PROJECT MEMO: 23 Ocean Avenue

RE: Response to Preliminary Staff Comments

Draft Subdivision Plat Review William Clark 07.11.2016

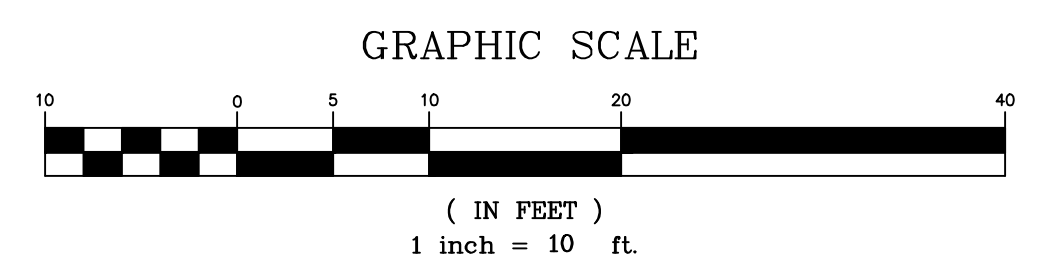
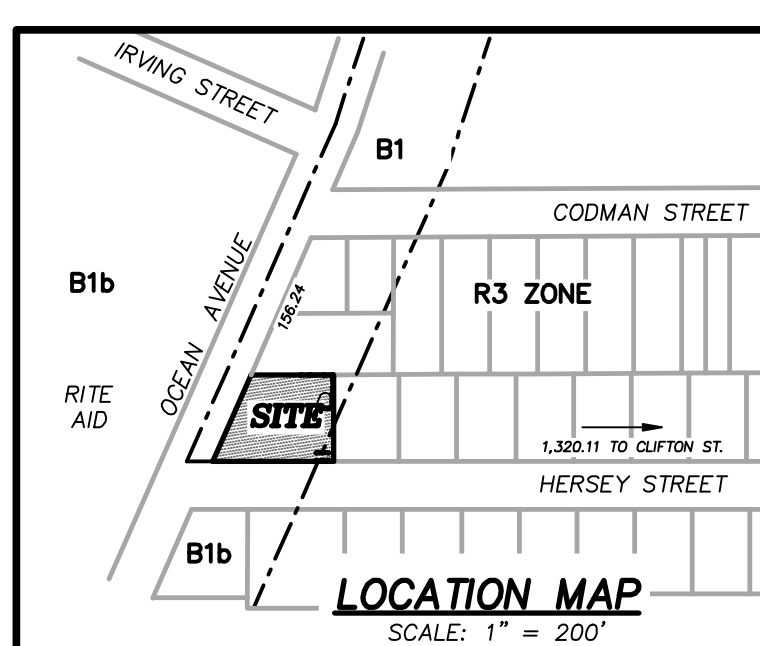
Comment #1. The sidewalk at corner of Ocean Ave and Hersey St shows as being constructed on the private property. Currently the sidewalk is within the City street ROW limits for Ocean Ave and Hersey St. If it is expanded onto the private property the City will need a public easement for that area and a detail on the plan showing bearings, distances, and curve data for the easement metes and bounds description.

Comment #2. The proposed aerial licenses in Ocean Ave and Hersey St will need bearings, distances, and curve data added to the plan for the license metes and bounds descriptions. The vertical clearance in the license areas will also need to be stated.

Comment #6. *A pedestrian easement will be required at the Ocean Avenue/Hersey Street intersection (a portion of the sidewalk is located on the applicants property).*

Comment #9. Show proposed easements and licenses.

Comment #10. Show Zone Line.

Response: The Final Subdivision Plat will show all public easements resulting from the new sidewalk configuration along Hersey Street and Ocean Avenue.

Response: The Final Subdivision Plat will show all licenses required to accommodate the footings, roof overhangs and canopy areas for the proposed building.

Response: The Subdivision Plat will indicate a public easement across the corner of Ocean and Hersey Street where the sidewalk encroaches onto the Applicant's property.

Response: The Final Subdivision Plat will include all easements and licenses required and described in other parts of this memo.

Response: The Final Subdivision Plat will show the Zone line between the B1 Zone and R3 Zone, which cuts across the southeast corner of the property.

**SITE PLAN**

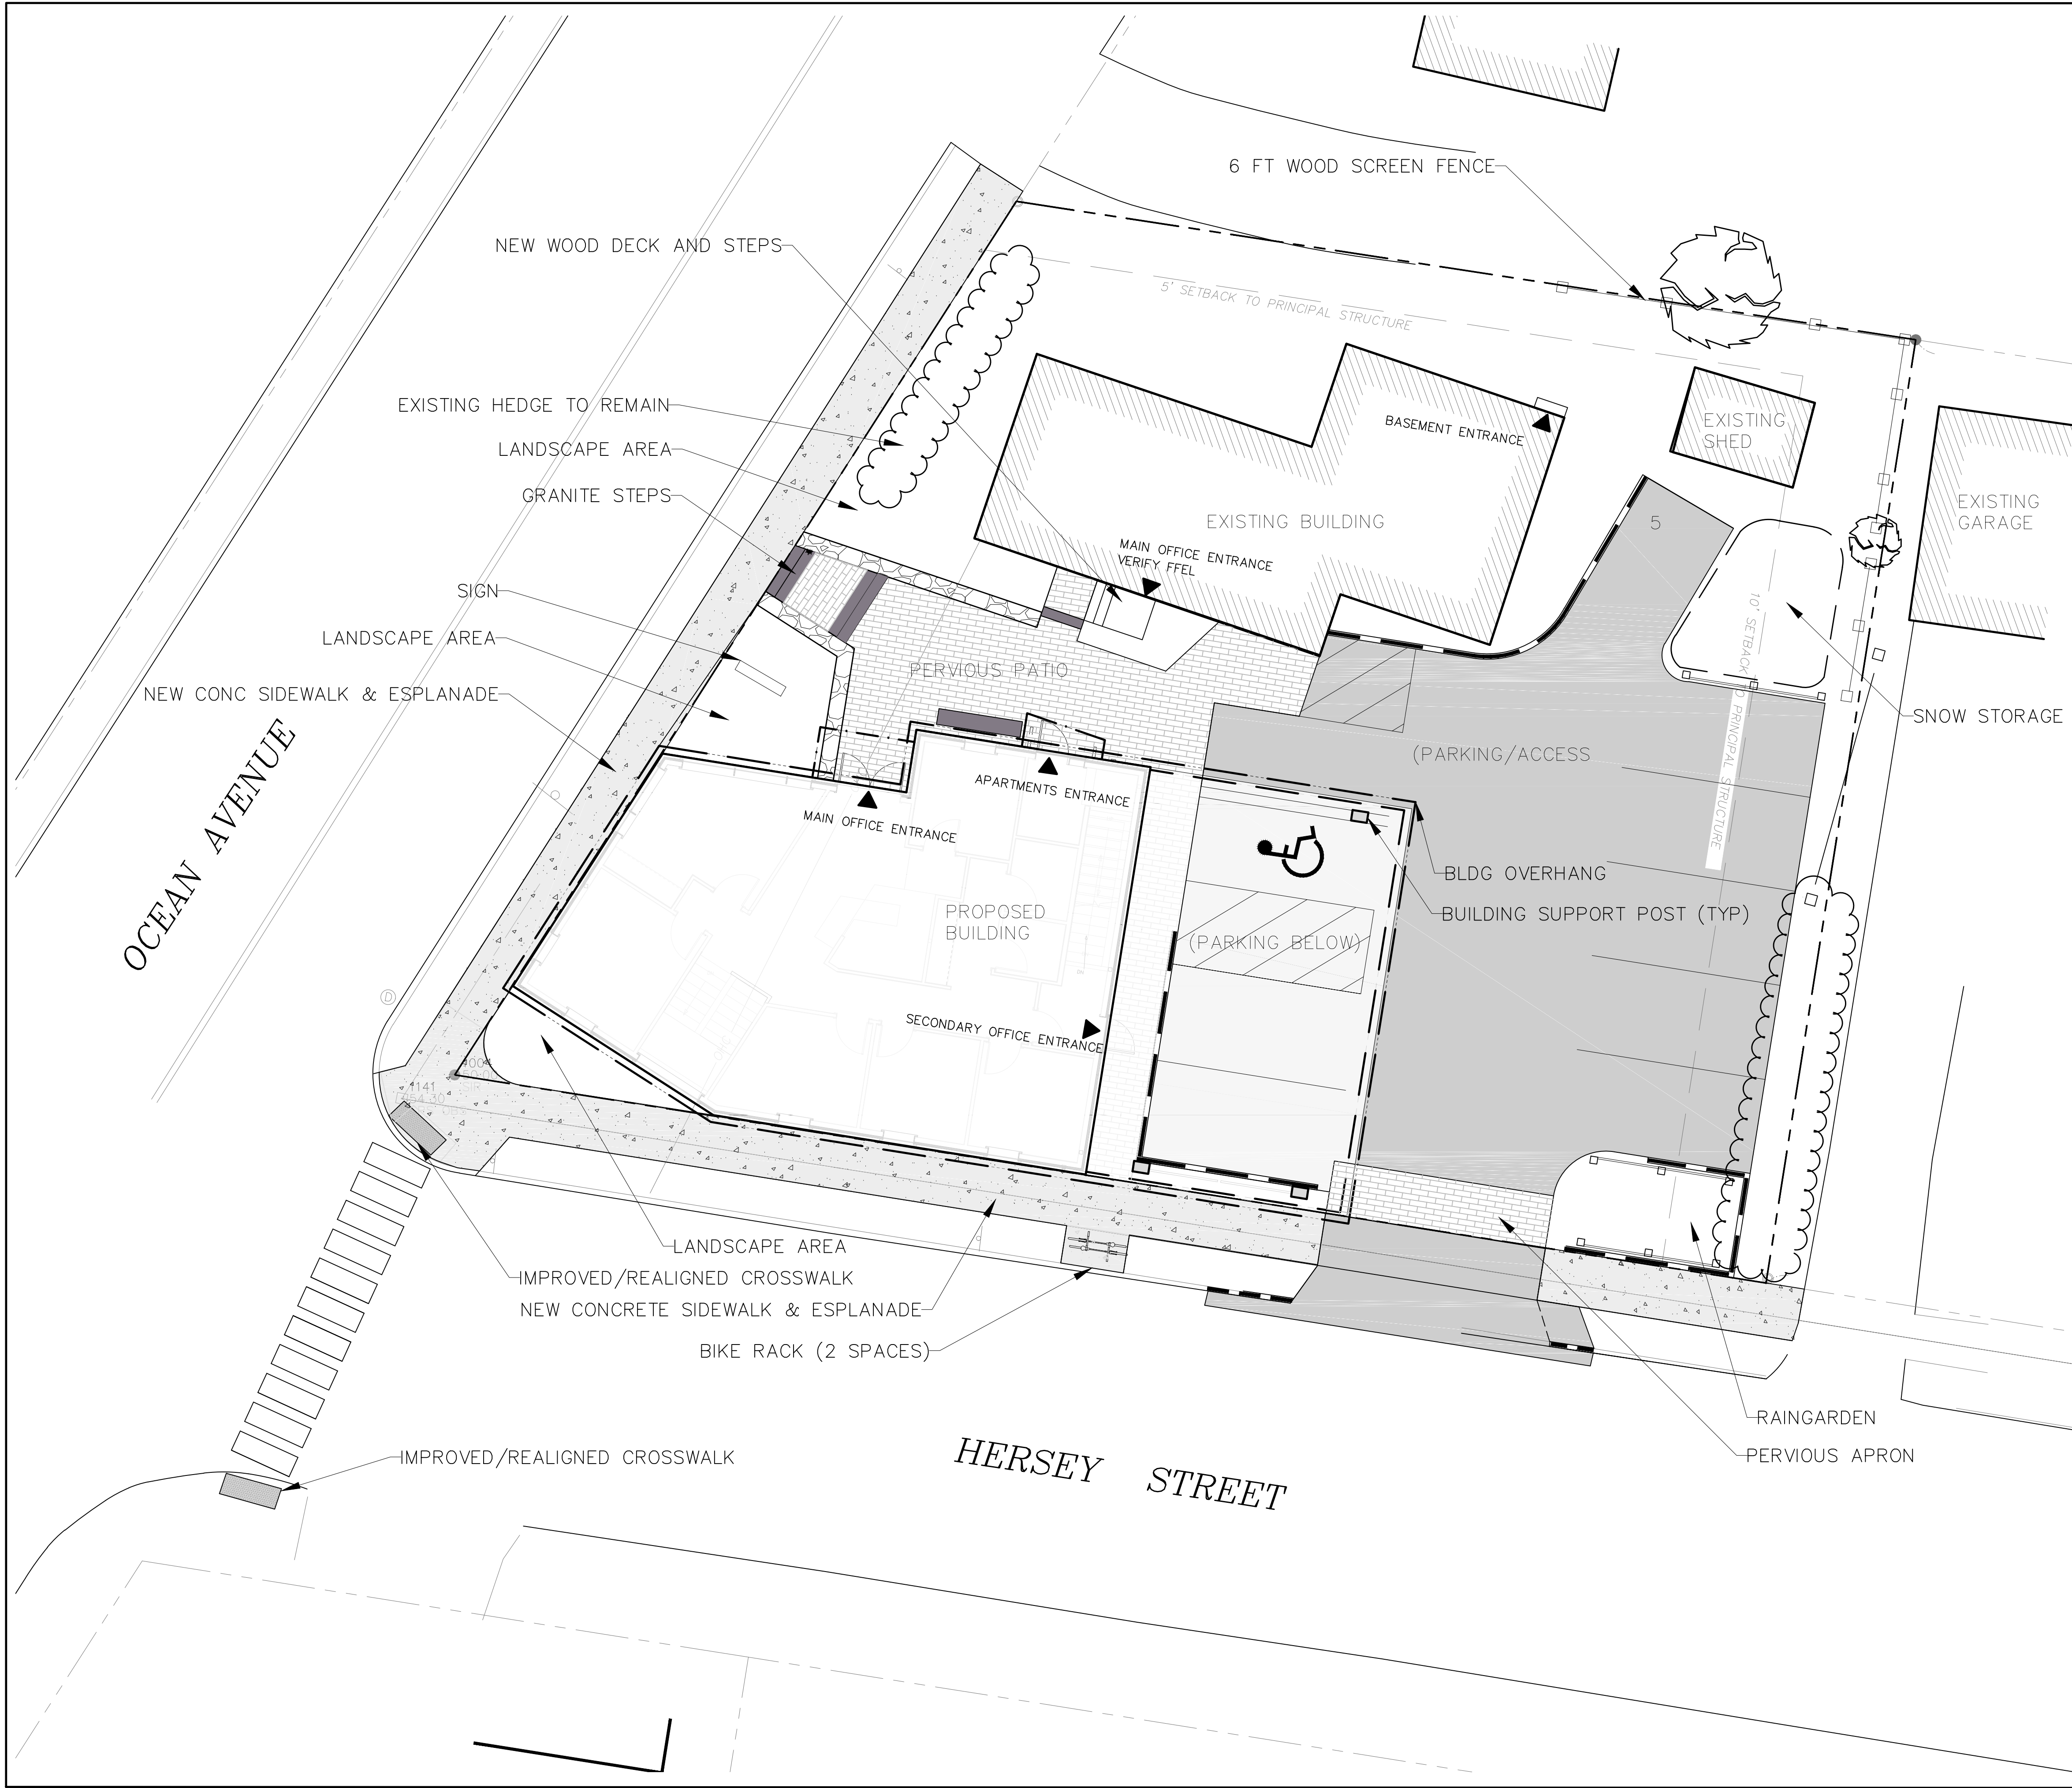
Comment #5. *I would prefer that backing maneuvers onto Hersey Street not be required and thus the applicant should either provide a layout that allows for on-site vehicle circulation – for head out egress, or supporting documentation on the proposed circulation condition.*

Comment #8. *The plans do not include full replacement of the sidewalk on Ocean Avenue along the entire property frontage. The applicant should either include full sidewalk replacement or document justification for the current proposal.*

Comment #1. Sidewalk should be reconstructed along entire length of Ocean Avenue frontage

Response: The site plan has been modified to allow on-site circulation without requiring any backing maneuvers onto Hersey Street. A dedicated turnaround area has been provided adjacent to the existing office building. This is illustrated in Exhibit #1 AUTOTURN which is attached to this memo.

Response: The site plan has been revised to indicate that the sidewalk will be replaced along the entire frontage on Ocean Avenue and Hersey Street.

Response: The site plan has been modified to indicate replacement of the sidewalk along the entire length of Ocean Avenue.

Drawing Title:  
**LANDSCAPE PLAN**

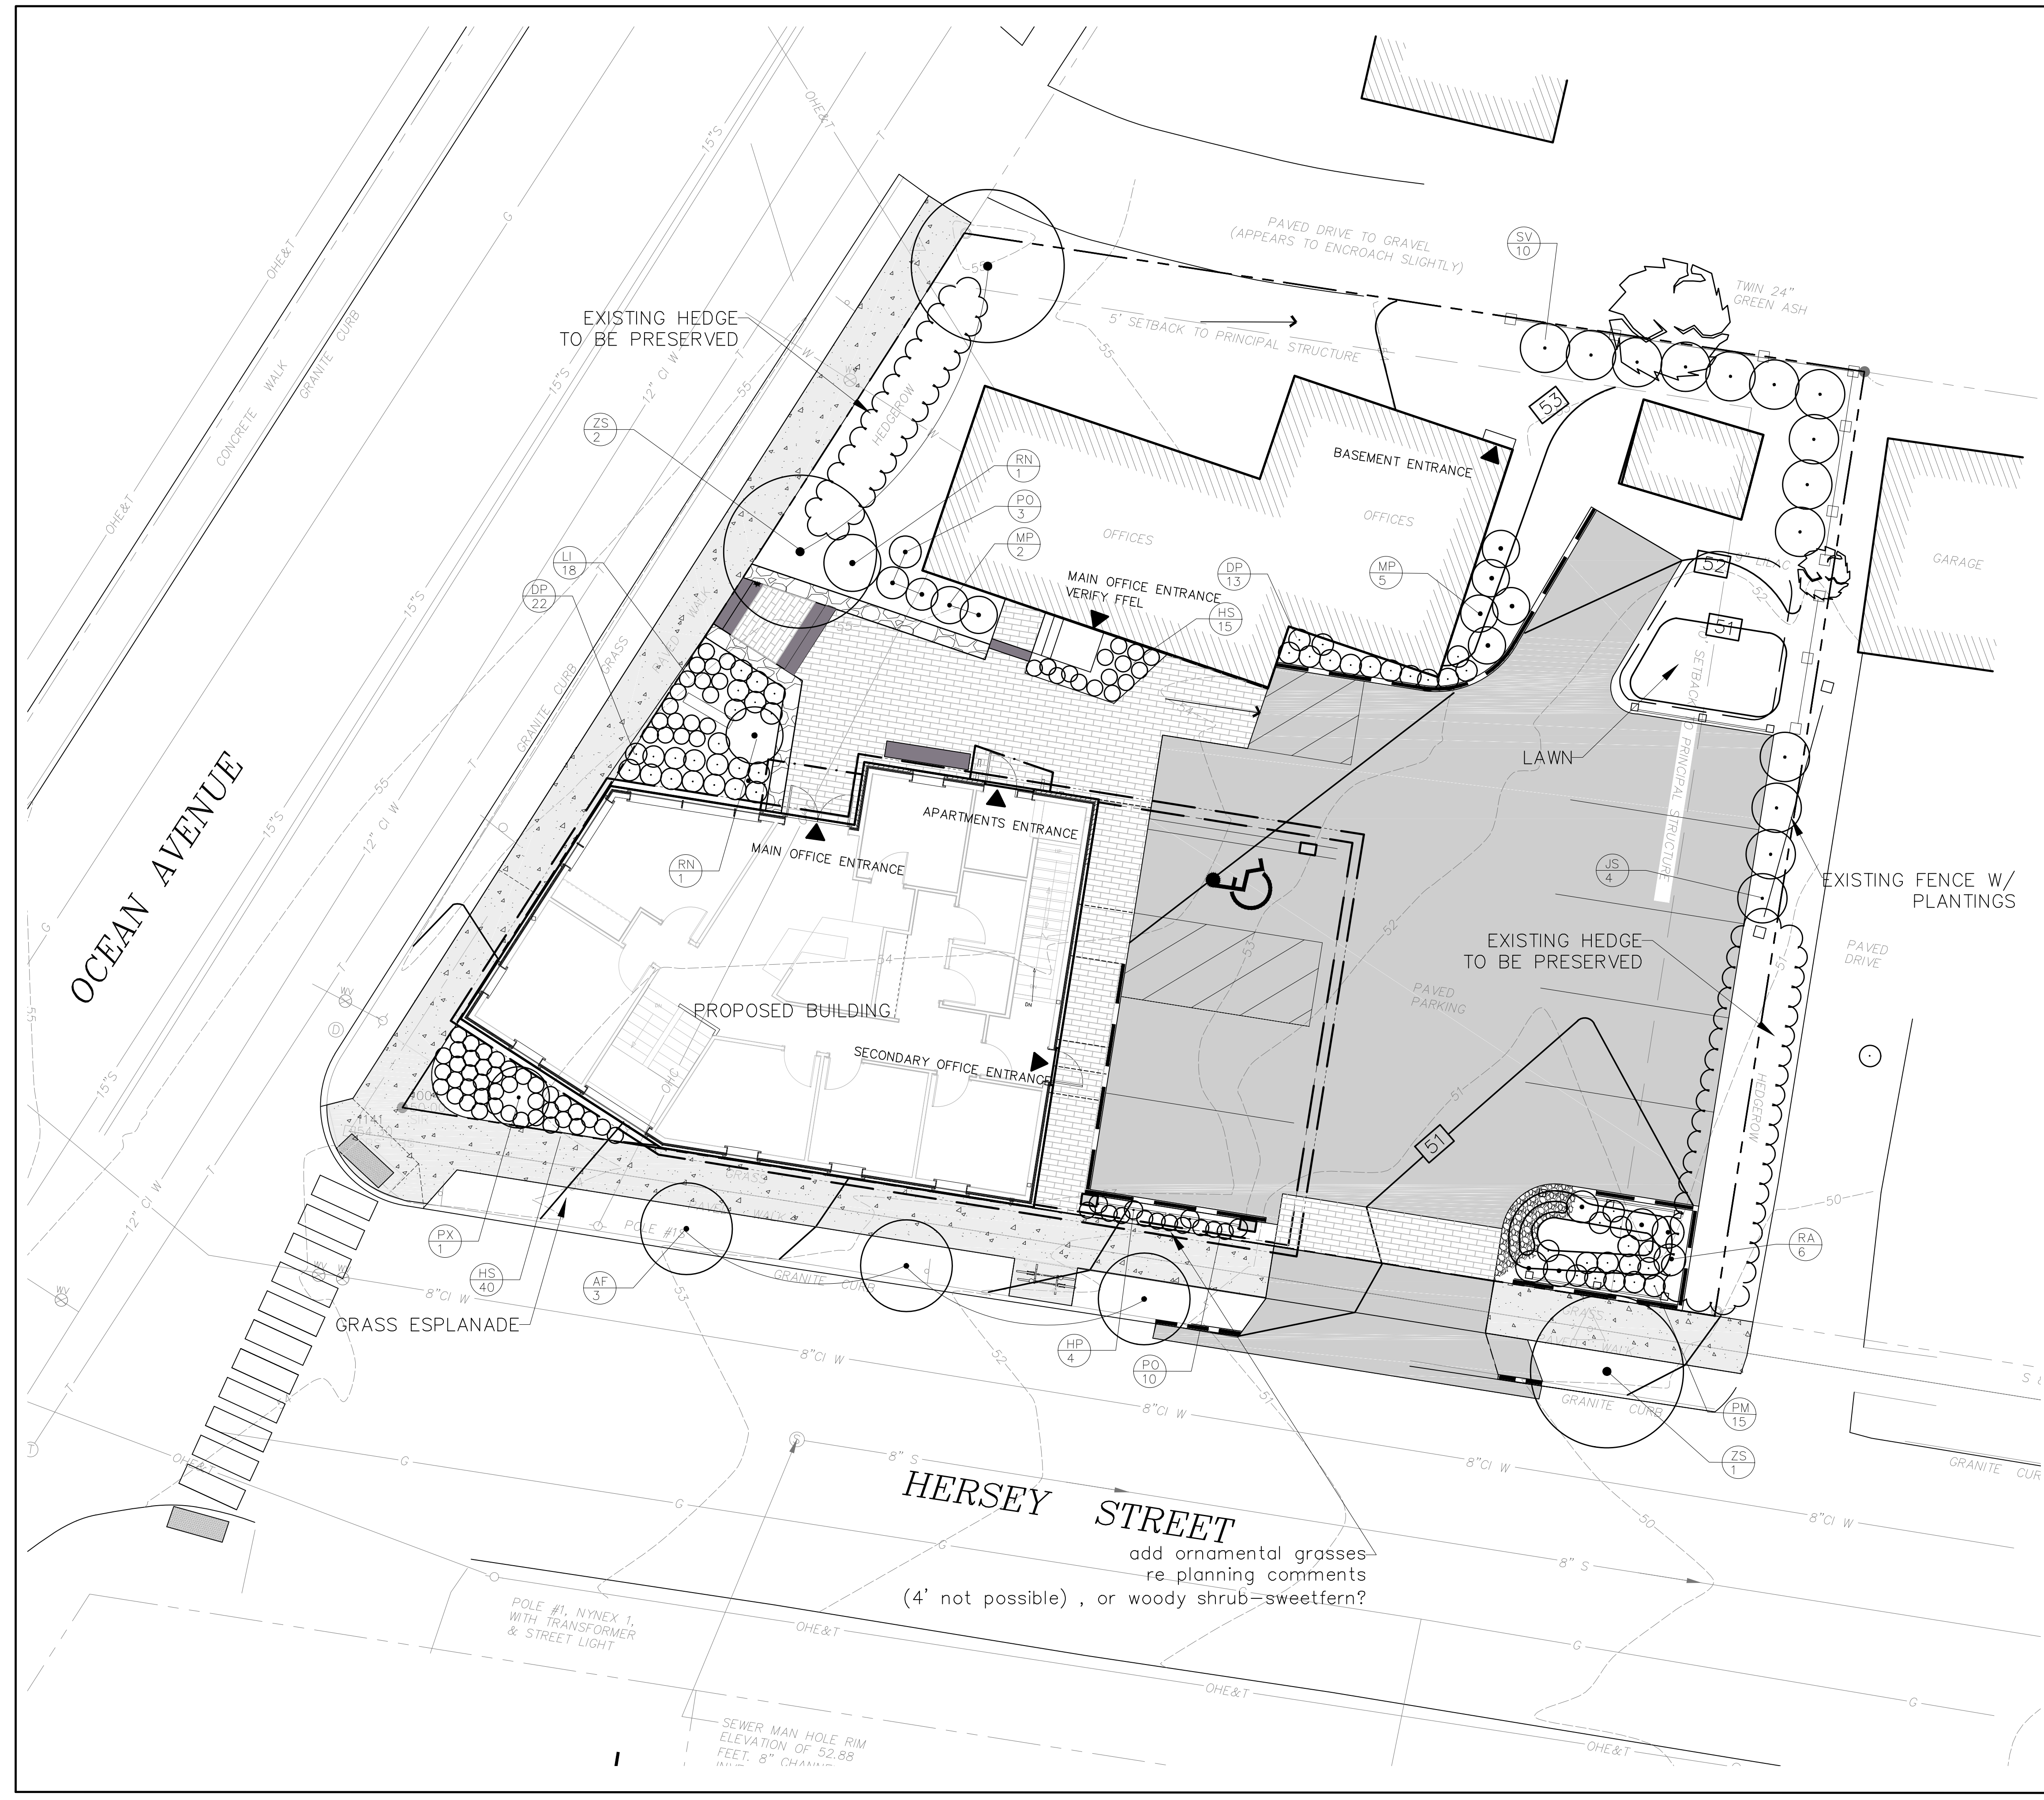
Comment #1. The existing esplanade width is problematic - just too narrow to support Street trees on both sides, Ocean & Hersey Street. I checked the entire length of Ocean Avenue and no existing street trees, also this is a busy truck / commercial vehicle route and tree canopy even on an upright tree would unlikely to survive. Snow storage in winter along with deicing salts, this sidewalk route is on our priority school walk route and we plow so we need as much space as possible.

Comment #2. Thus we would like to see 'set-back' tree planting in available spaces. Also parking lot on Hersey Street should have a 4' buffer with plant material at back of sidewalk. A smaller 3' or 2' buffer might not make it. Ideally like to see woody shrub planting but could do ornamental grasses. Wood guardrail on the parking lot side is needed to protect this space from vehicles, snow etc. Without protection plant material would likely be damaged. This buffer on the residential side is more important than the more commercial Ocean Avenue side. Add a couple of trees on the parking lot edge to buffer parking lot from next door residential use. See photos, (I got creative with the pics.

Comment #4. Landscaping and Landscape Preservation. Provide additional evergreen landscaping on eastern property line where site abuts residential zone.

Response: The landscape plan has been modified to eliminate street trees along Ocean Avenue. We believe with the reconfiguration of the Hersey Street sidewalk that there is adequate room (+/- 4.5 ft) in the esplanade to install street trees and they will be effective in reducing the scale of the building. We are therefore proposing to install 4 street trees along Hersey Street. We have also added two trees along Ocean Avenue on the back side of the sidewalk north of the proposed building.

Response: The landscape plan has been revised to accommodate a guardrail along the Hersey Street sidewalk and significant vegetated buffer associated with the adjacent rain garden. Additionally, the hedgerow has been extended along the east and north property lines to provide screening and privacy for the abutting residential neighbors.

Response: The landscape plan has been revised to include a mixture of evergreen and deciduous landscaping along the eastern property line where existing vegetation does not provide adequate buffer and screening.
